Development Control  
Ribble Valley Borough Council

**Re: Planning Application 21/0311**

**Address: Brockhall Farm Brockhall Village Old Langho BB6 8BB**

Director of Highways and Transport  
Lancashire County Council  
PO Box 100 · County Hall · Preston · PR1 0LD  
[www.lancashire.gov.uk](http://www.lancashire.gov.uk)

Client	Brockhall Farm		
Project	Brockhall Farm redevelopment		
Title	Access mitigation		
Purpose of Issue	<input type="checkbox"/> For Information <input checked="" type="checkbox"/> Preliminary		
Drawn	AJC	Checked	AD
Scale	A4 Plot 1:500	Date	7/1/2021
Drawing No.	J1194 access fig 2	Rev

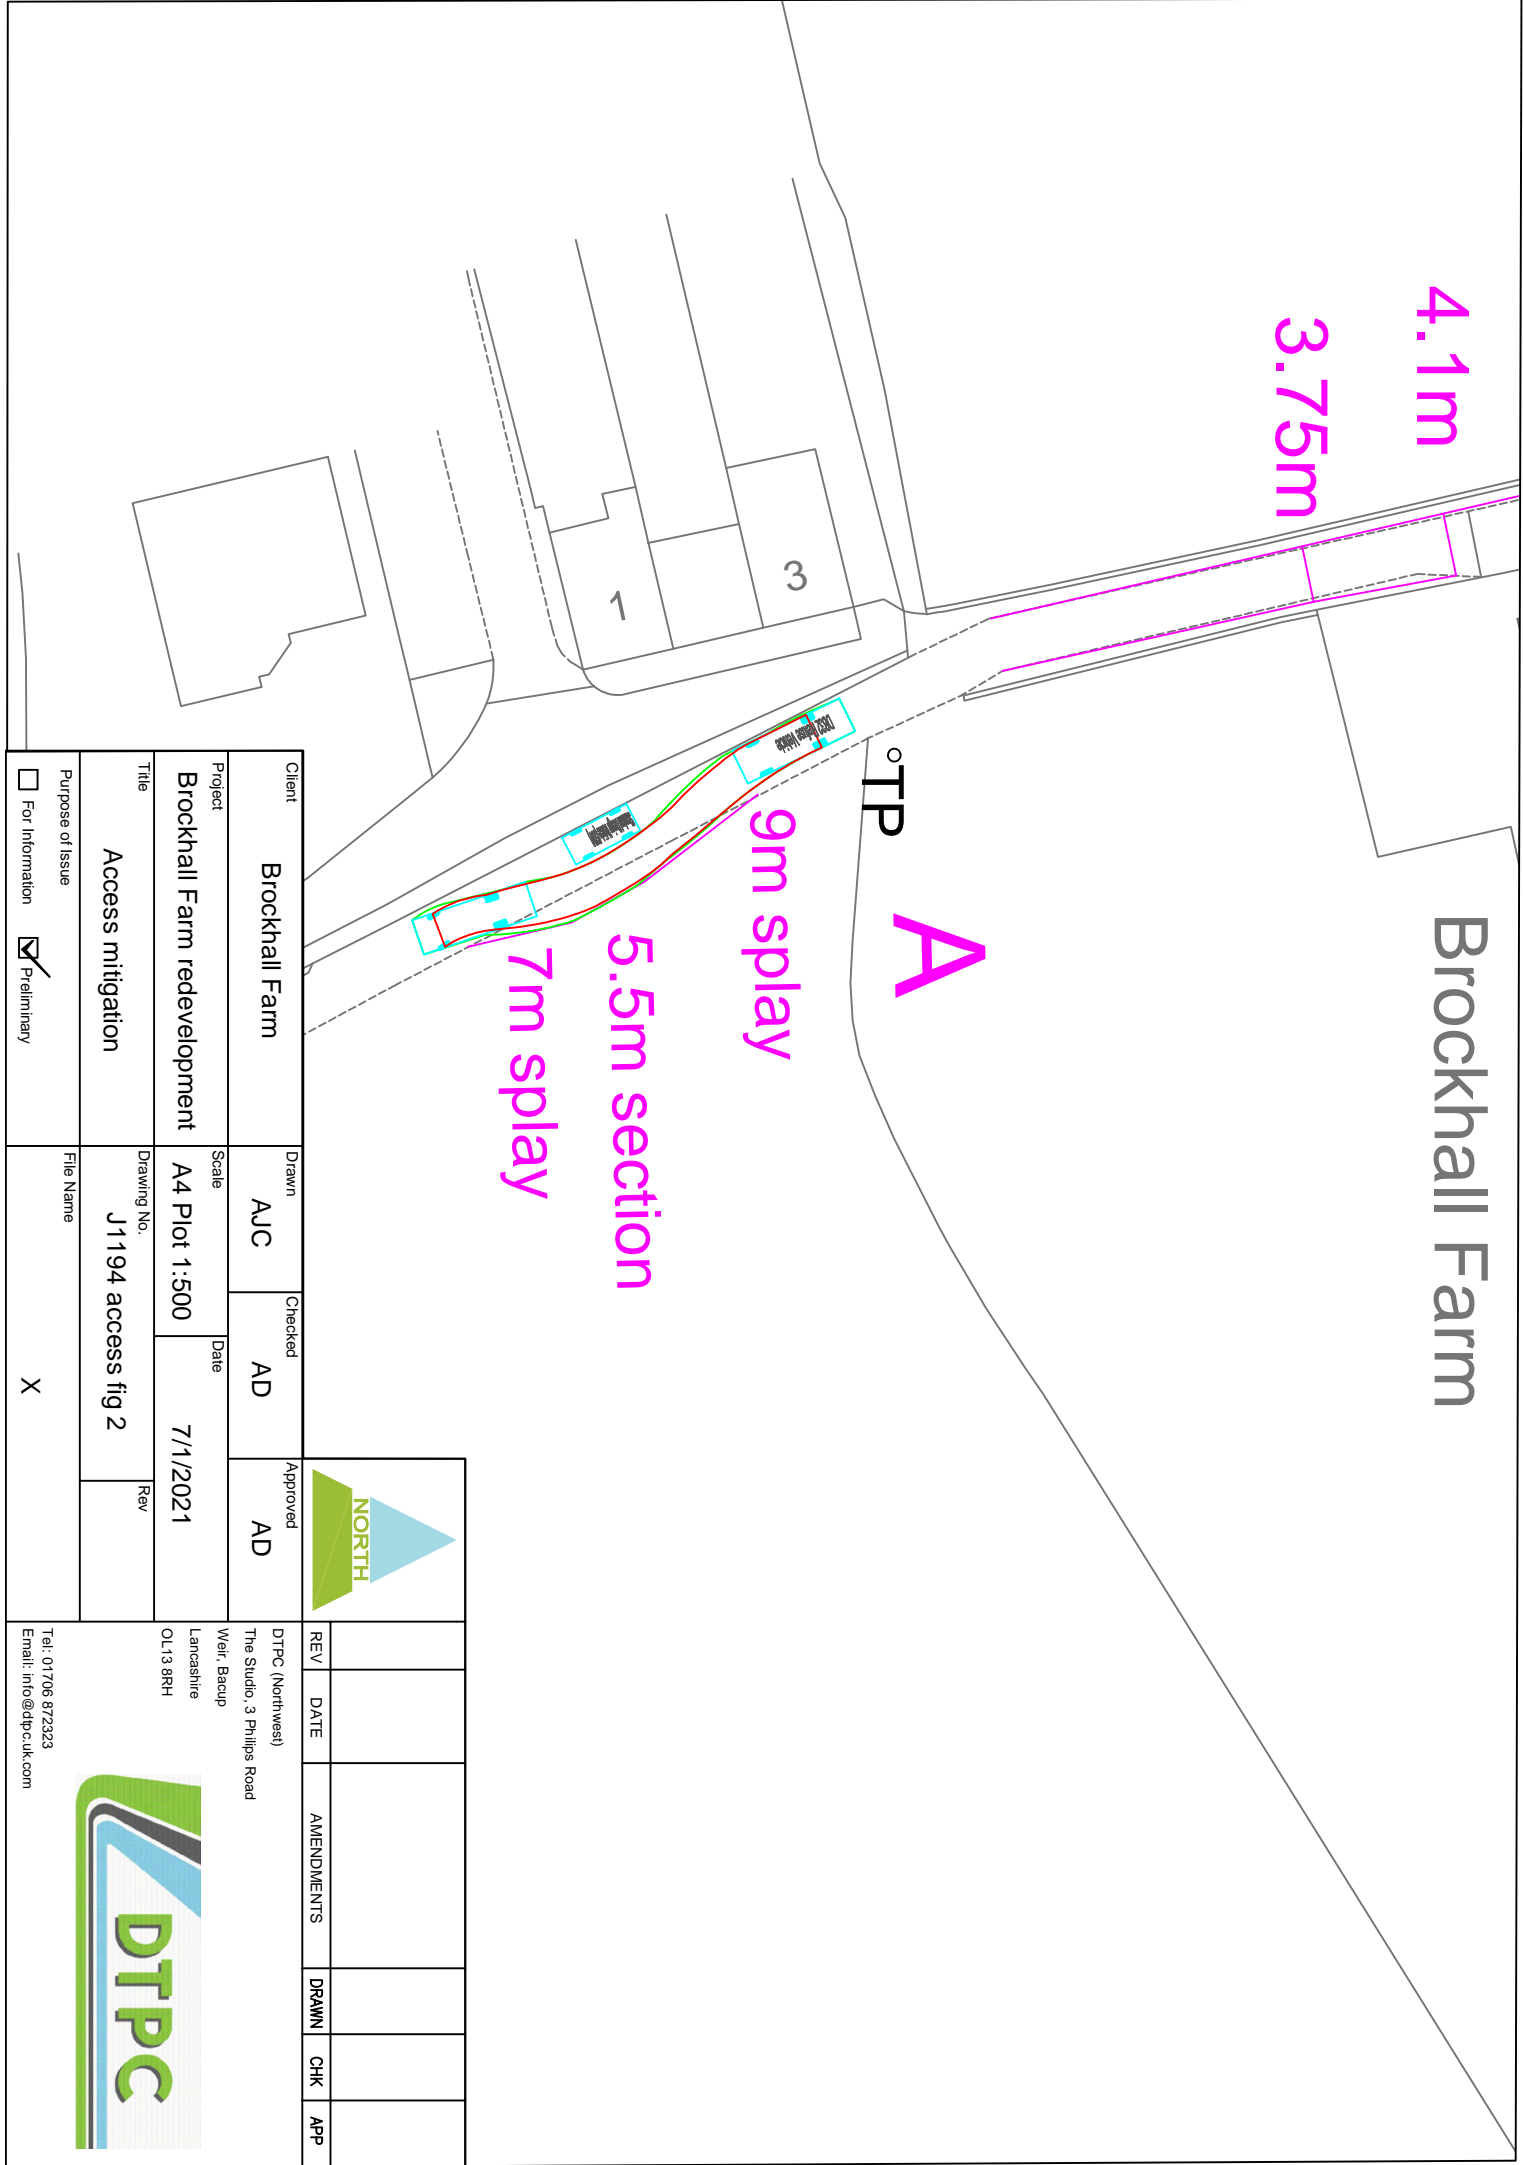
There are however concerns regarding the access along the track to the rear of Larkhill including the lack of pedestrian facilities at the cattle grid to the rear of Bradyll Court and the lack of general maintenance contributions from the applicant to the upkeep of track.

Whilst a swept path analysis has been undertaken for a refuse collection vehicle for the passing places, there is no indication as to if the rest of the land is to be farmed. It is advised that the passing places should be of sufficiently large enough to accommodate the

passing of tractor with trailer and the refuse vehicle. An additional passing place should be considered at the start of access track adjacent to 25 Larkhill.

The existing cattle grid will require up grading to accommodate a suitable access for pedestrians.
